Charlotte Department of Transportation

Memorandum

Date: March 27, 2009

Subject: Rezoning Petition 08-147: located on the north side of Brookshire Boulevard between Oakdale Road and Caldwell Williams Road (*revised 3/20/09*)

1 SITE LAYOUT & PAVING PLAN
C-1
Scale: 1" = 60'

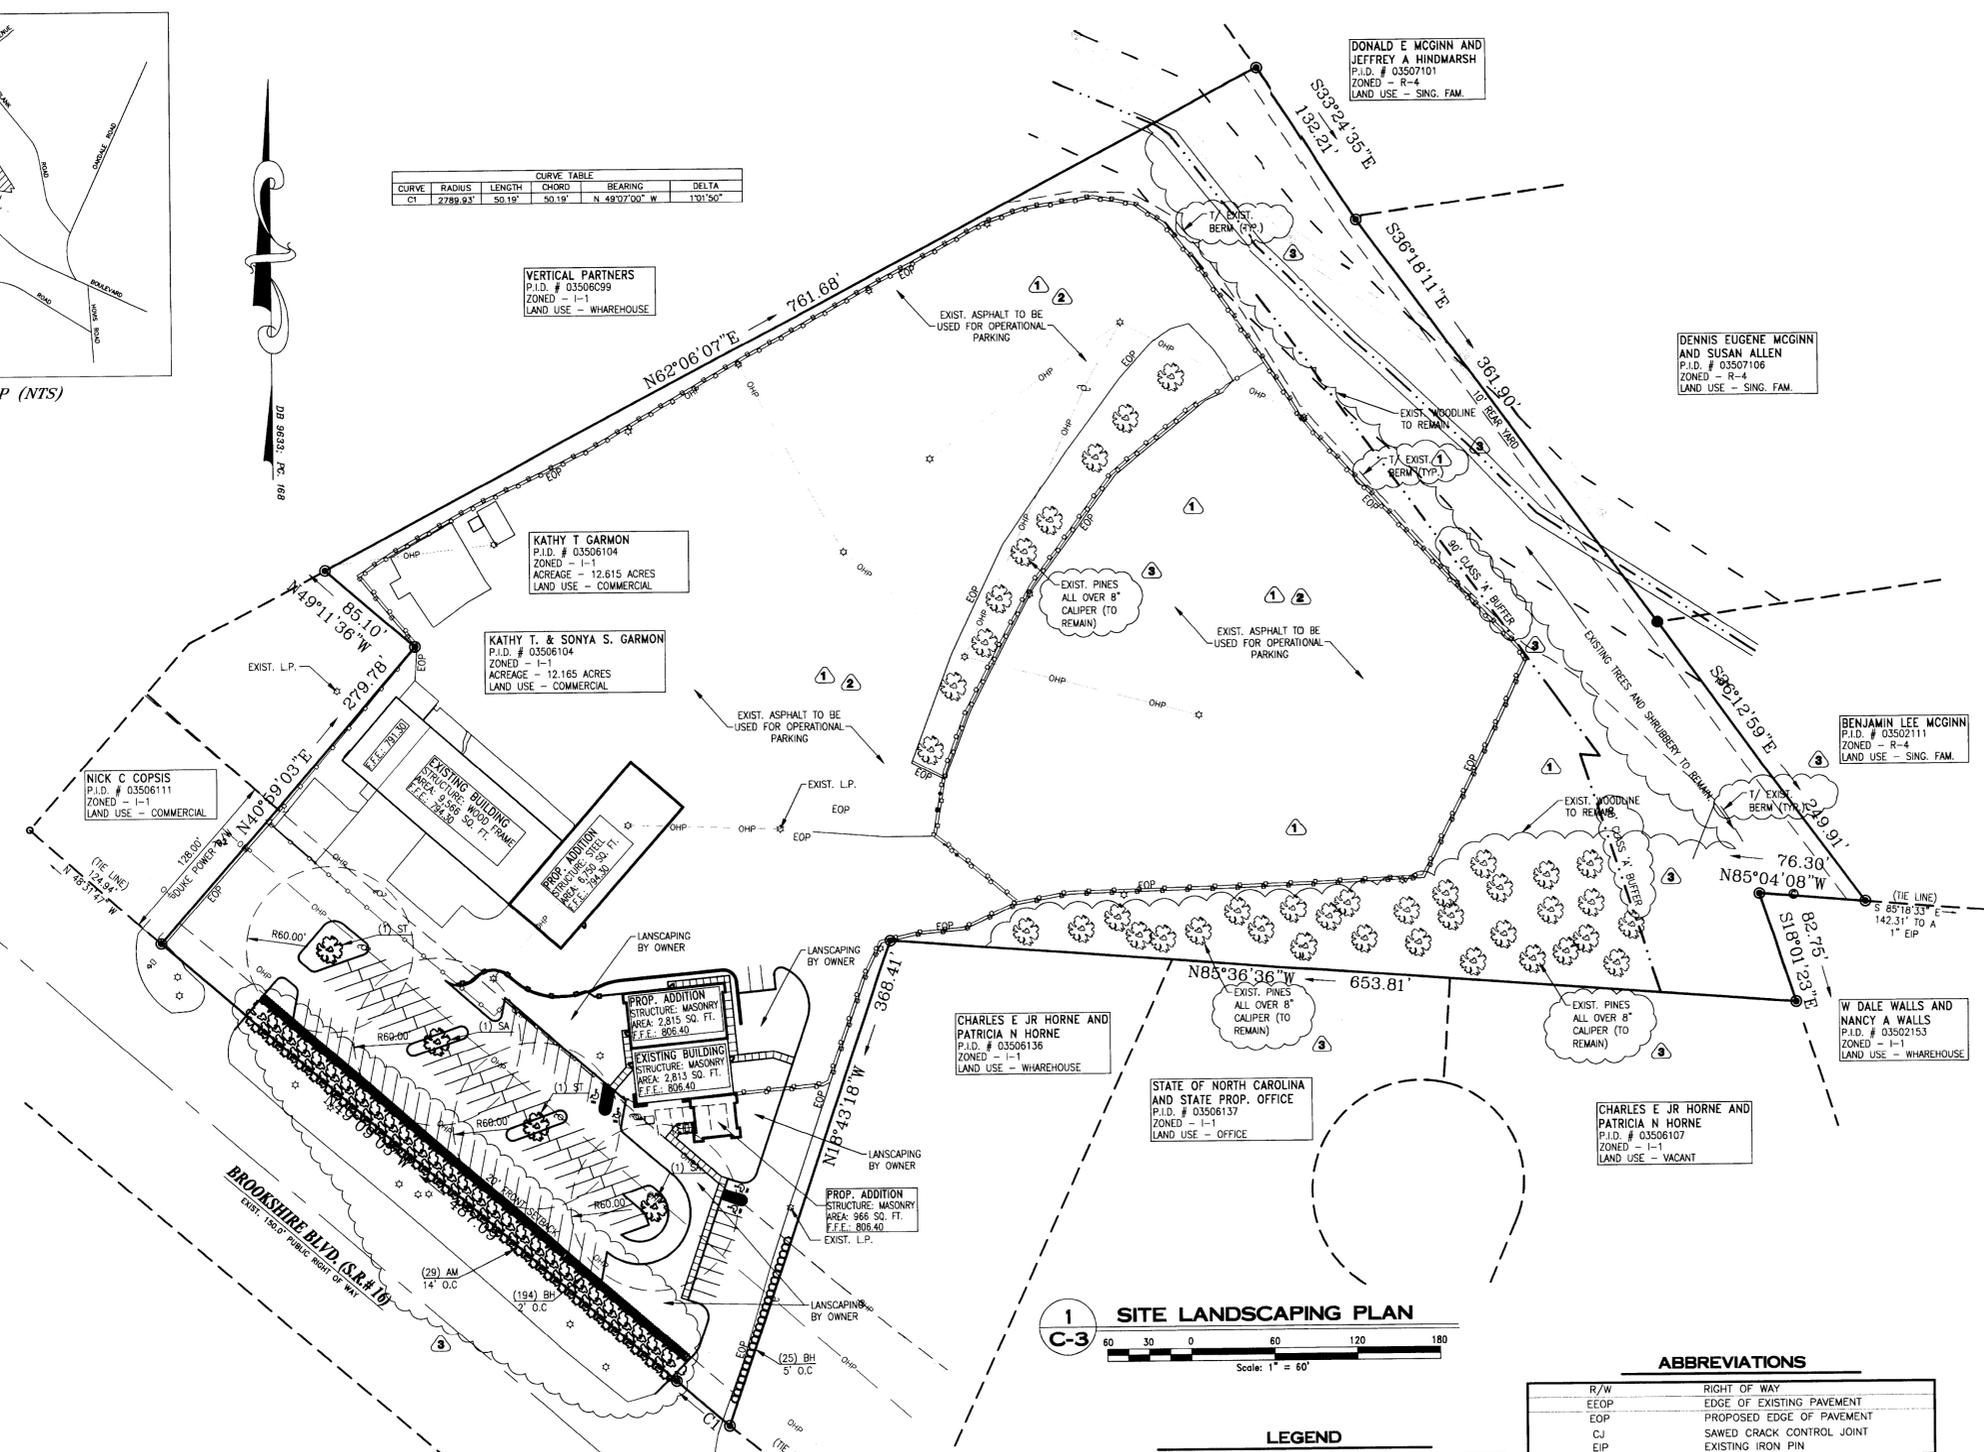
1. The most current site plan indicates the passenger vehicle access driveway location has changed from previous submittals. The existing driveway in the middle of the site is now proposed as the primarily vehicular access point; however this driveway does not meet minimum standards for access. This driveway needs to be upgraded to a Type III driveway meeting the minimum width of 26 feet and the radii designed to accommodate an SU-30 vehicle which may be accessing the existing and proposed building on the northern portion of the site.

2. The southernmost driveway to the site, which will be primarily used as the truck entrance, is indicated as "Type II" on the site plan. A Type III driveway is required for truck entrances to site. The width and radii of the driveway need to be designed to accommodate a WB-50 design vehicle.

3. The locations of the gates along the 8' security fence along the existing and proposed large buildings needs to be shown on the site plan to further evaluate the circulation of the SU-30 vehicle which may access these two buildings.

4. A conditional note needs to be added to the site plan that triggers when site improvements, including the construction of two (2) new driveways and closing the northern most existing driveway.

5. The proposed driveway connection to Brookshire Boulevard will require driveway permits to be submitted to CDOT and the North Carolina Department of Transportation for review and

approval. NCDOT may also require a right-turn deceleration lane on Brookshire Boulevard into the site's driveways. The exact driveway location and type/width of the driveway will be determined by CDOT during the driveway permit process. The locations of the driveway shown on the site plan are subject to change in order to align with driveway(s) on the opposite side of the street and comply with City Driveway Regulations and the City Tree Ordinance.
